From:
Sent: 12 March 2026 18:12
To: Jennifer Booth; DC Admin
Subject: Objection to planning application PP-14717946- 2026/90484

Application PP-14717946
Site Address: 143 Church Lane, Gomersal, Cleckheaton, BD19 4QN

I write to formally object to the above planning application relating to the extension, refurbishment and change of use of 143 Church Lane from a dwellinghouse to a Use Class C2 residential institution accommodating up to four children. While the reuse of vacant buildings can be beneficial in principle, I have significant concerns regarding the accuracy of the information submitted within the application and the potential impacts of the proposal on the surrounding residential area. I respectfully request that the Local Planning Authority carefully review the following issues before determining the application.

## Proposed Plans & Elevations

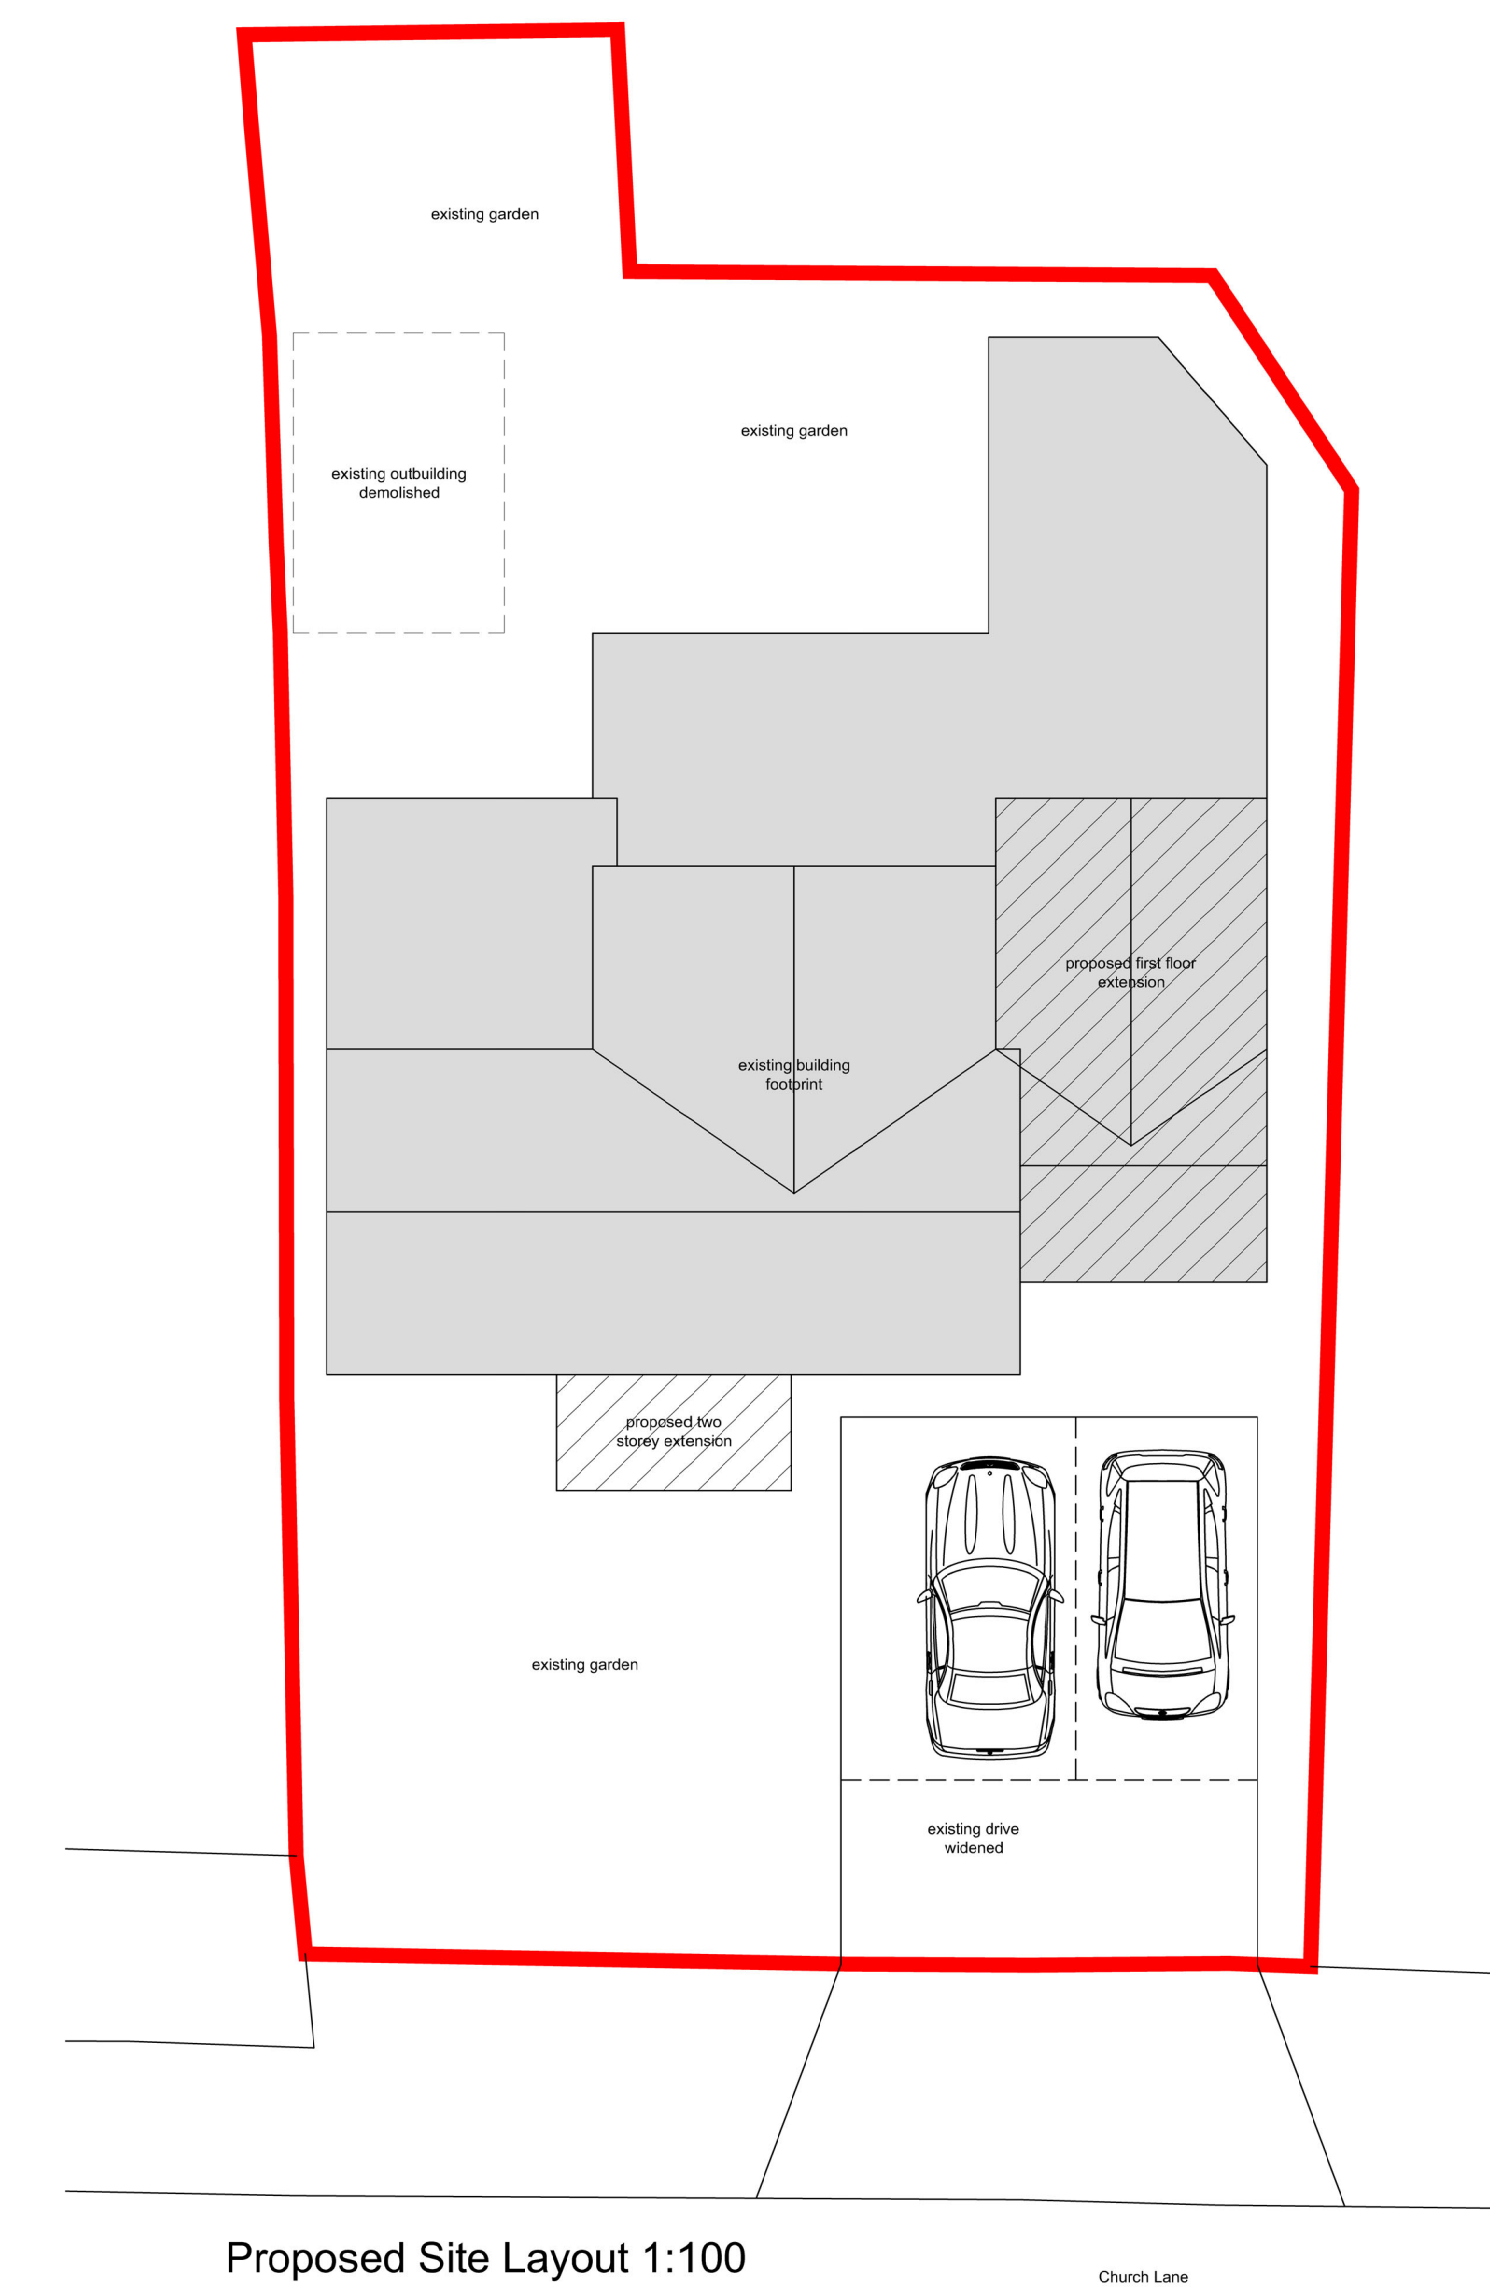
However, the most significant concern relates to parking provision and the potential impact on highway safety. The application indicates that the development would employ one full-time and five part-time staff members but proposes only two on-site parking spaces. Given the nature of a residential care setting, it is highly likely that staff will work in shifts, meaning that vehicles associated with staff members may overlap during shift changes. This raises

a clear risk that additional vehicles will be forced to park on Church Lane. As I'm sure you are aware Church Lane is a residential road, and the section immediately outside the property is situated on an uphill stretch within 10 metres of the junction with The Coppice. Parking associated with the property has already resulted in significant visibility issues and obstruction since December 2025. Multiple complaints have been made to West Yorkshire Police and Kirklees Council by myself and neighbouring residents regarding vehicles parking outside the property. On several occasions drivers have come close to road traffic accidents because their visibility when exiting The Coppice was completely obstructed. When vehicles park on the roadside outside the property, the view up Church Lane becomes dangerously restricted. This is particularly concerning given the proximity of the junction. Rule 243 of the Highway Code advises against parking near junctions or in positions that obstruct the road or endanger other road users. While the rule itself may not automatically constitute a statutory offence, parking in such a location may still be considered an unnecessary obstruction or dangerous positioning under road traffic legislation. In this context, the level of parking provision proposed appears inadequate and risks creating unacceptable pressure for on-street parking, which would adversely affect highway safety and the residential amenity of neighbouring properties.
